SSD 15_7101/ D/2015/1049 – 1 Alfred Street, 19-31A Pitt Street Sydney

Matrix of Government Agency Submissions and Proponent Response

drawing title  
MASSING ENVELOPE  
BASEMENT 3-6

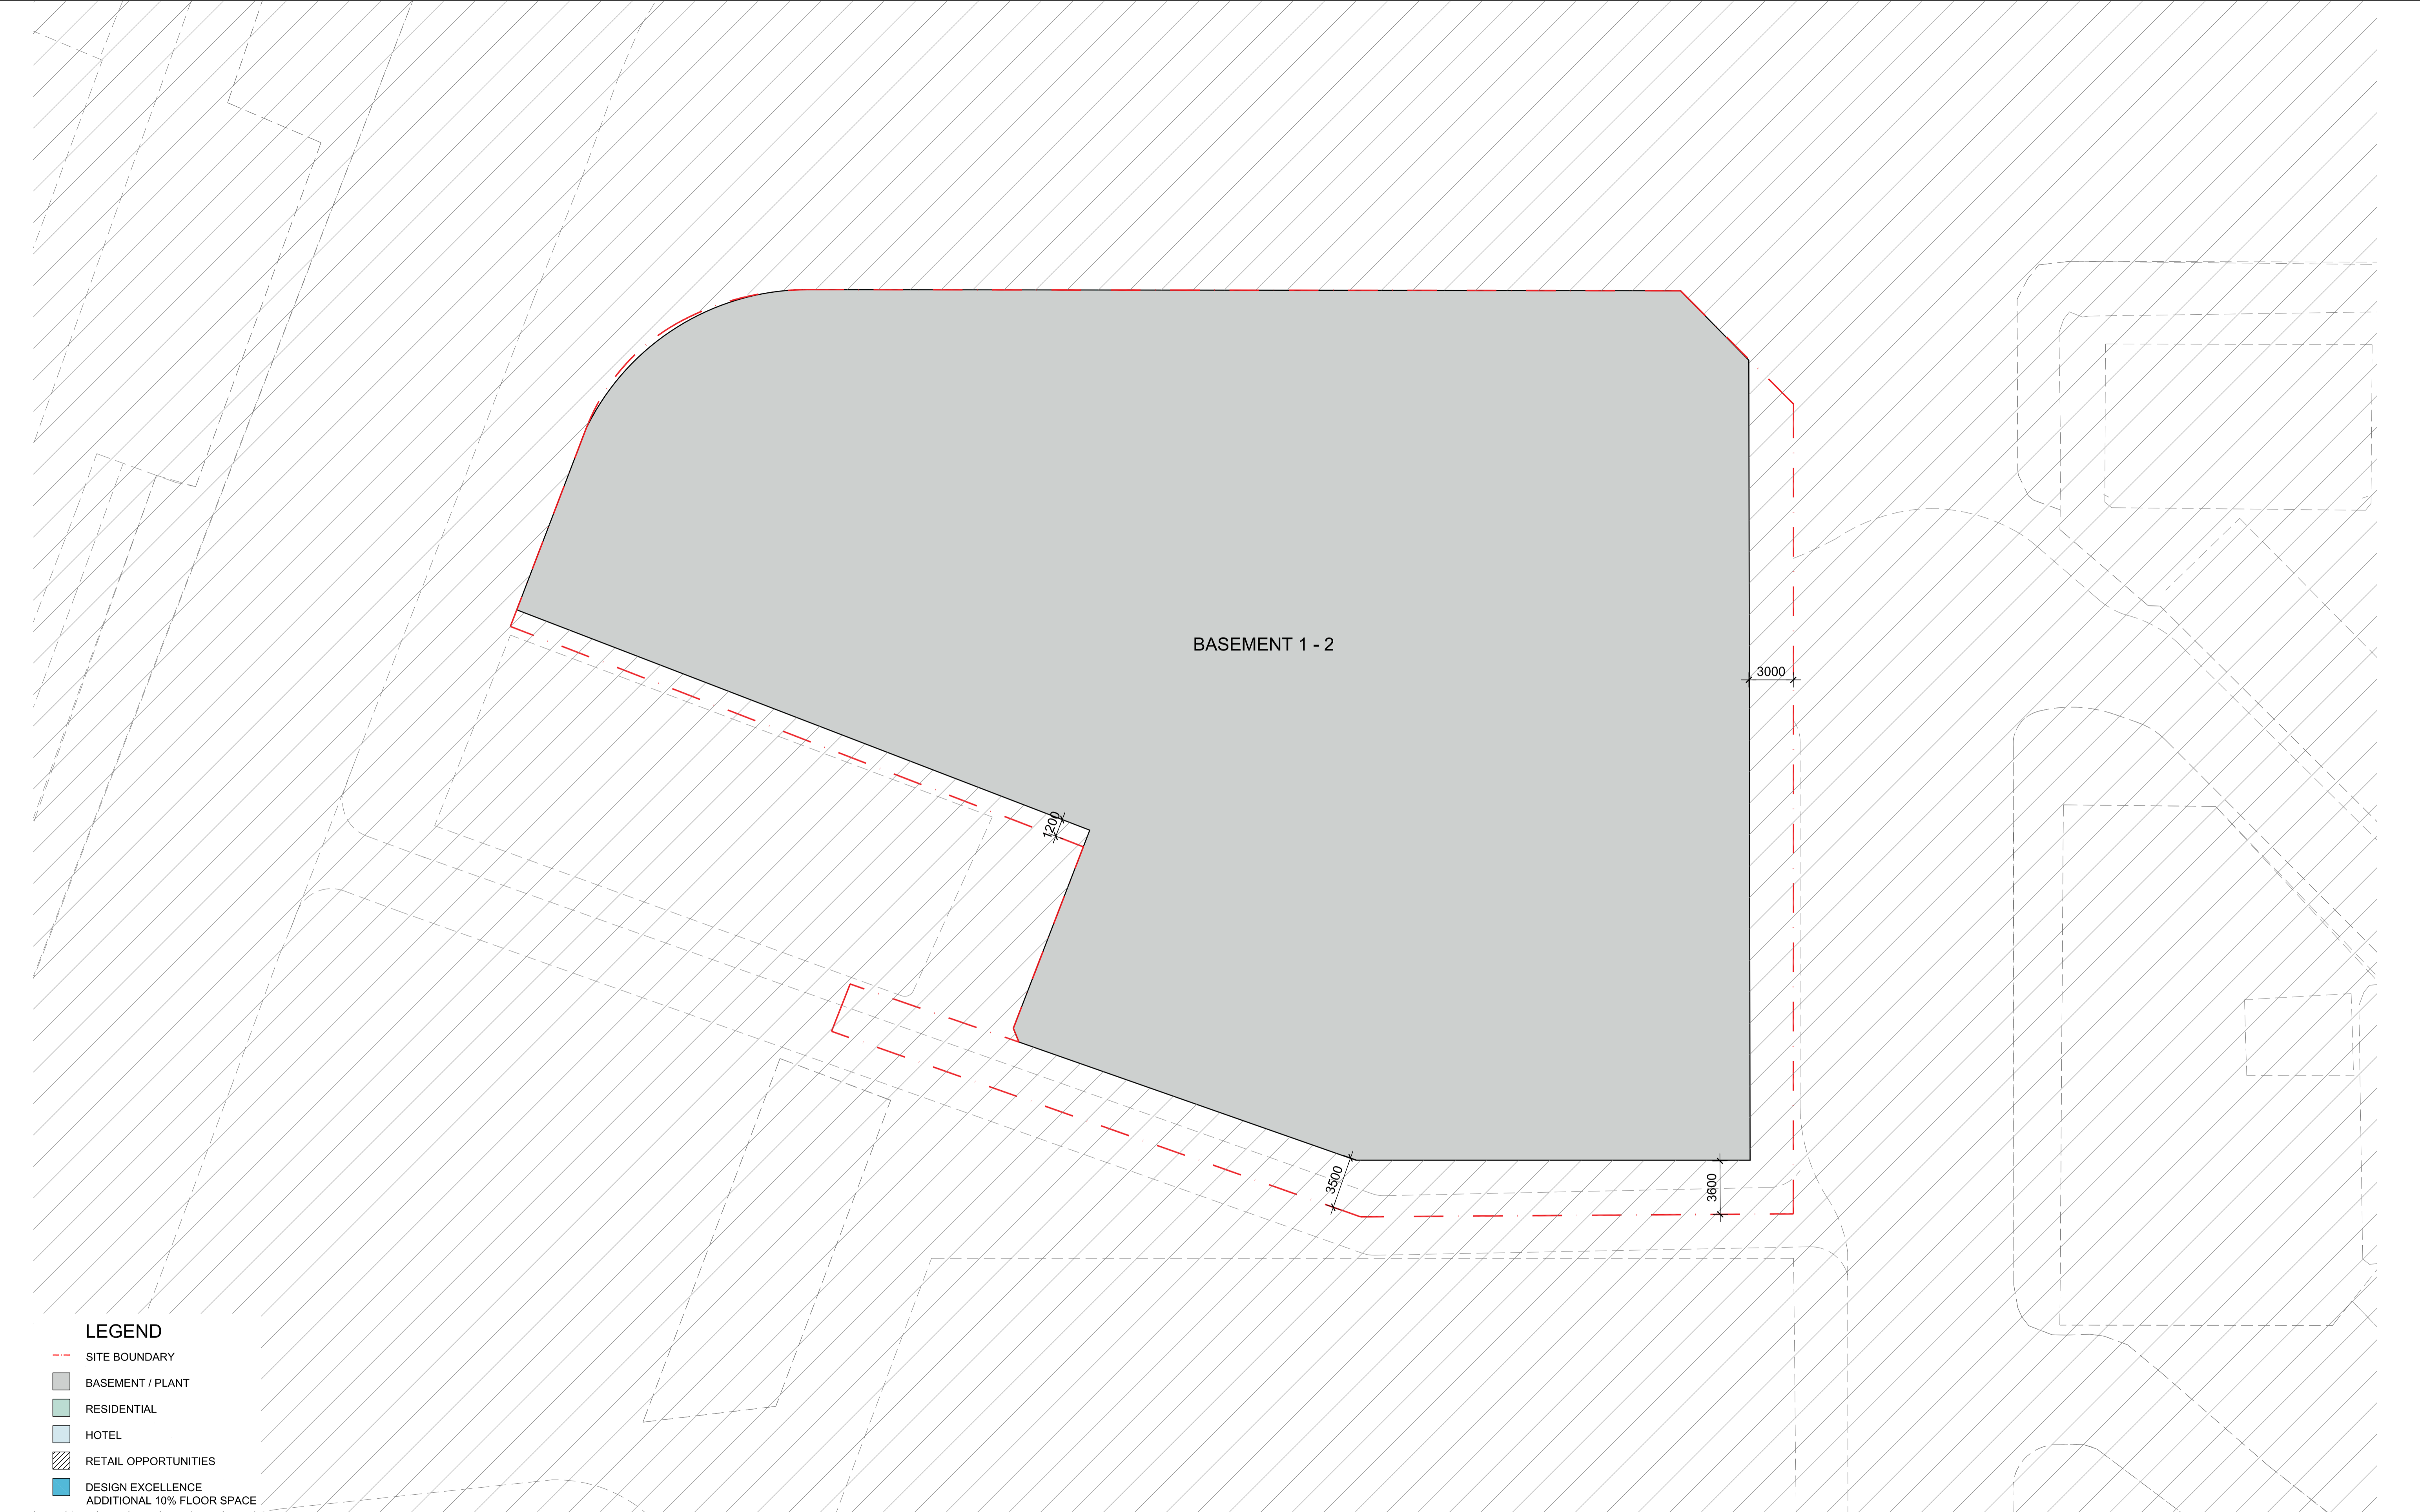
No building or permanent structure is to be constructed within 1m from the outside wall of the stormwater assets.

The submitted concept plan is to be revised to ensure that the proposed buildings and permanent structures are 1m away from the outside face of the Sydney Water's stormwater assets.

The basement has been amended with the intention to provide 1m clearance from all Sydney Water Stormwater assets, as illustrated in the image below:

As part of the detailed design development application for the basement, further investigation will be performed prior (including considering additional survey data and Sydney Water line potholing information) to demonstrate that the required clearances are maintained.
